**Awel y Môr Offshore Wind Farm Project Issue Specific Hearing 3 on the Substation Site and Related Matters – Action Points**

**8 December 2022**

**To be actioned at or by Deadline 4 (30 January 2023)**

FIGURE NUMBER:
 Figure 2

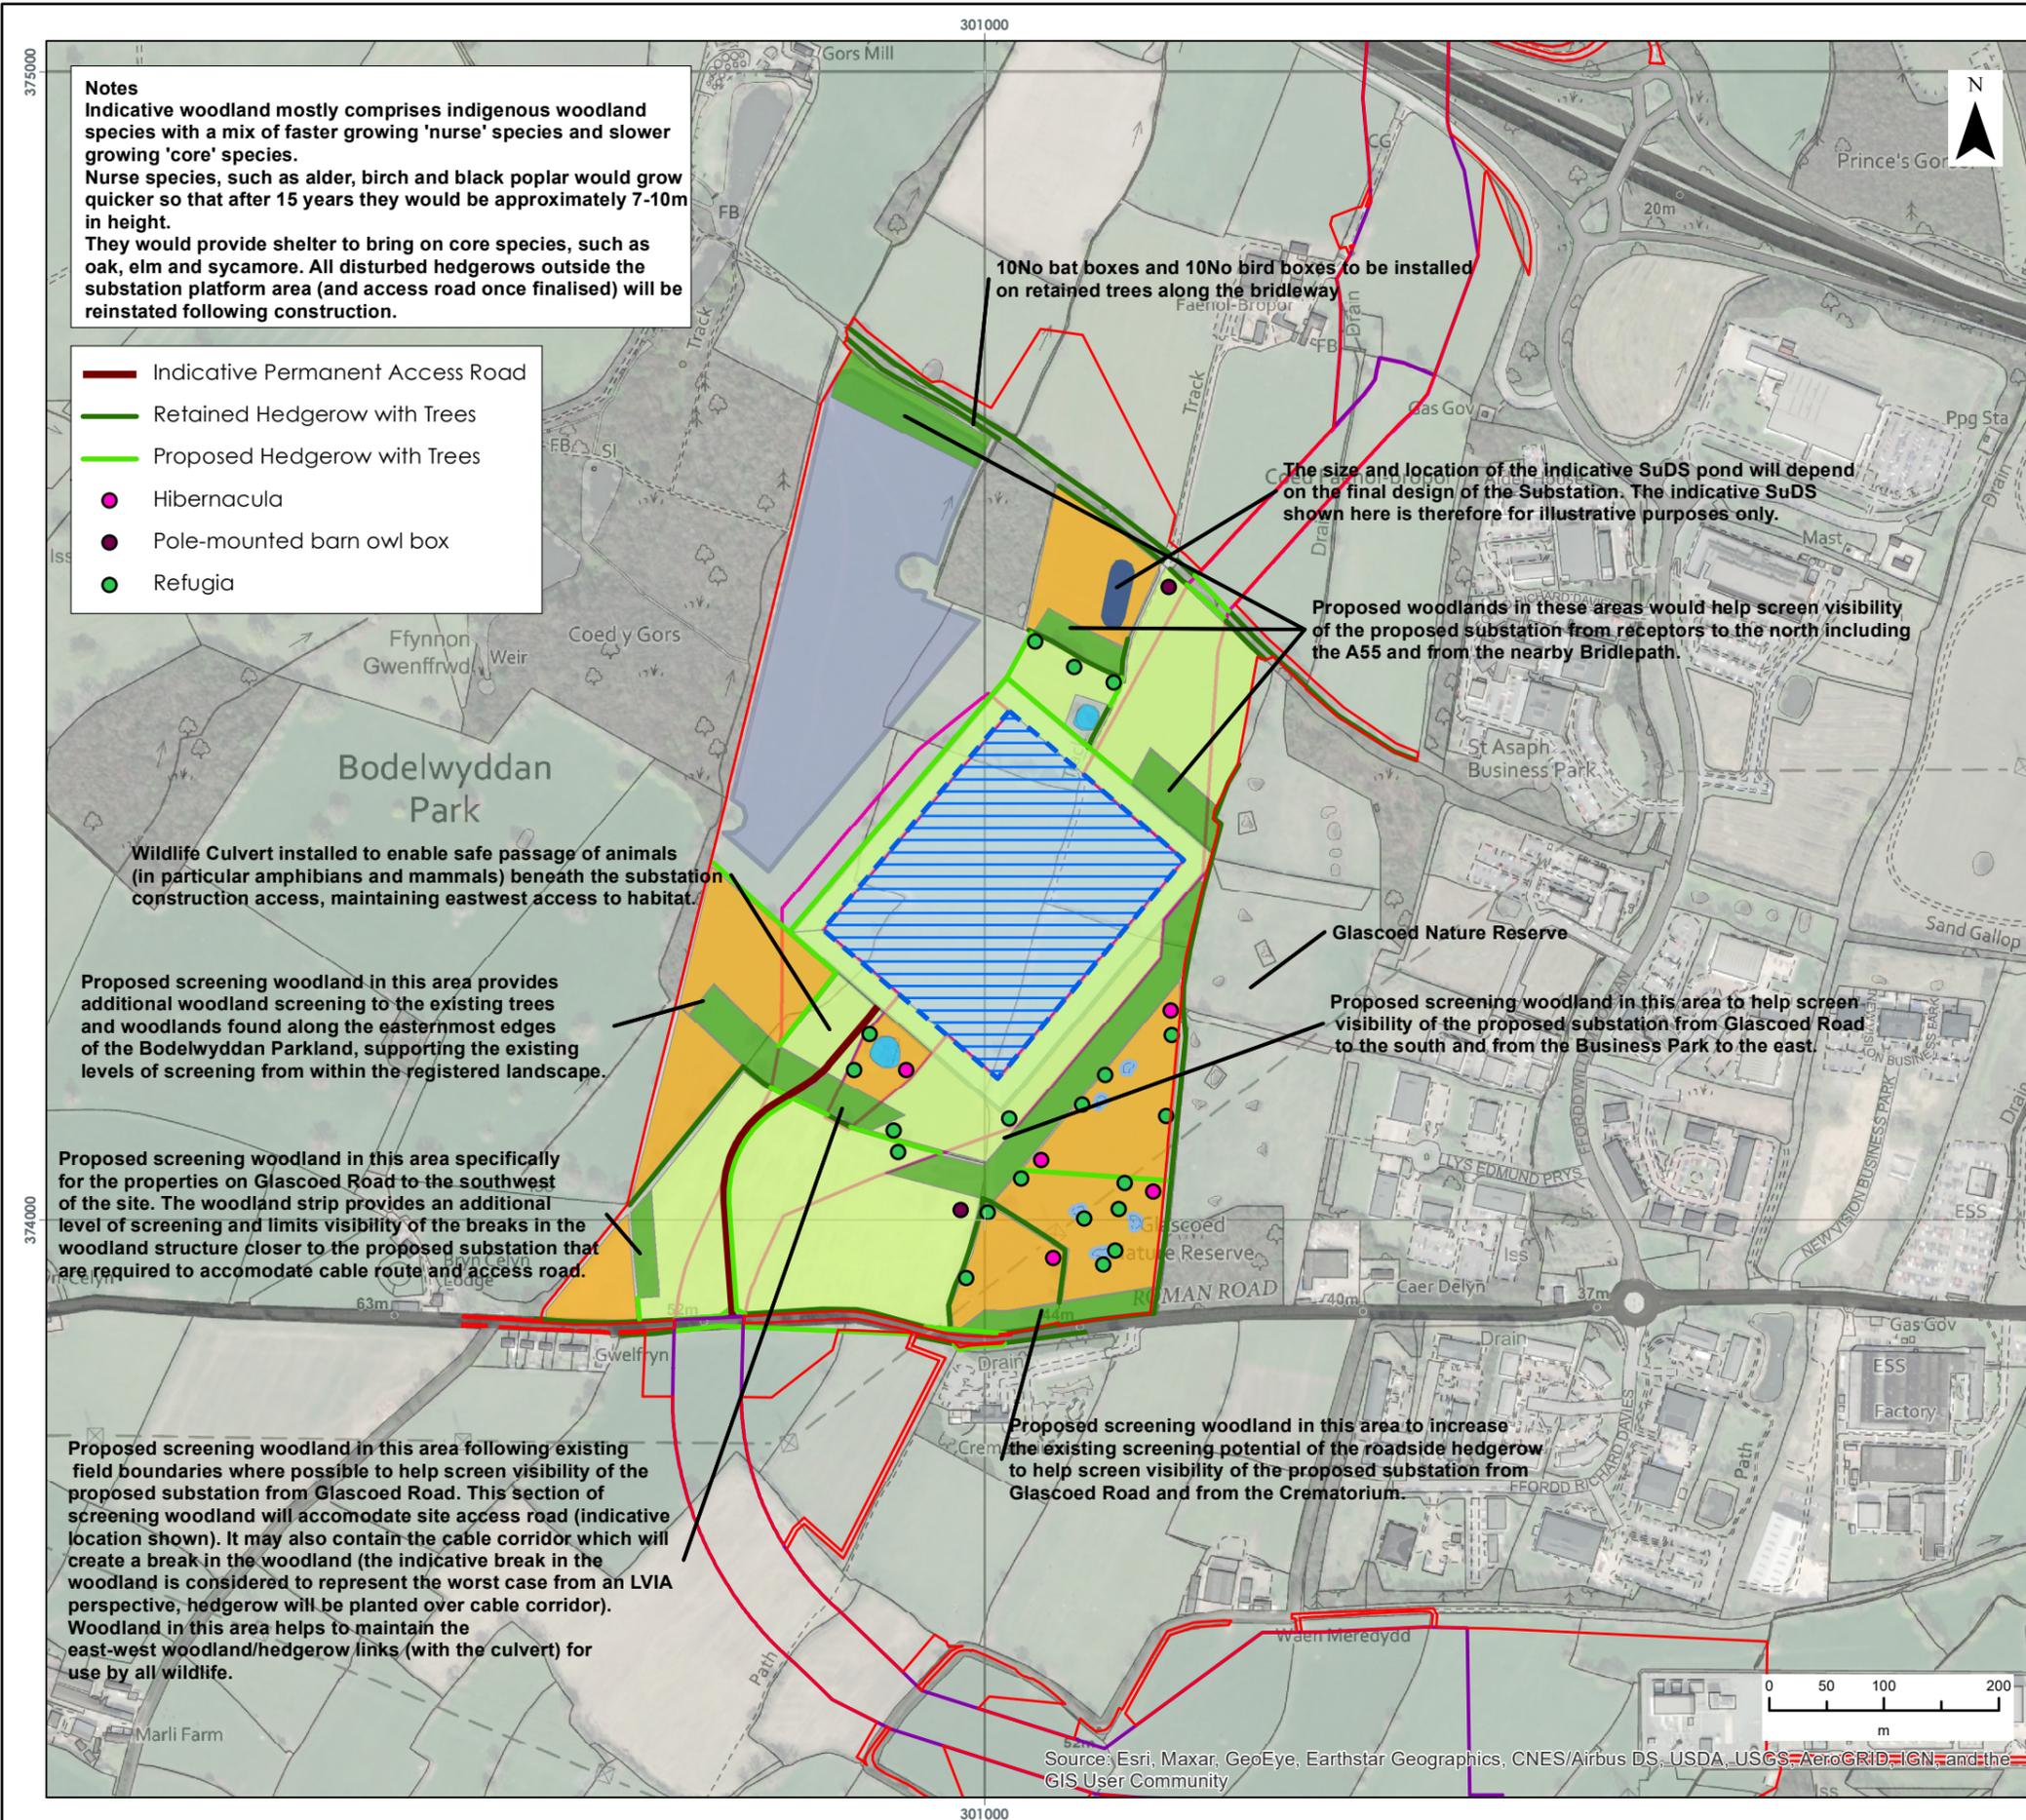
Applicant	<b>Mr Davies</b> To respond in writing to the representations made by Mr Davies during ISH3.
Applicant	<b>Temporary Construction Compound (TCC)</b> To review whether the details of the temporary office and welfare facilities within the TCC are secured within the Design Principles Document and the draft Development Consent Order (dDCO).
Applicant	<b>Longer-term Maintenance</b> To review drafting of the outline Landscape and Ecology Management Plan (oLEMP) in respect of longer-term maintenance.
Applicant	<b>Advanced Planting</b> To consider advance planting in southeast and southwest area of the site as part of a review of the oLEMP.
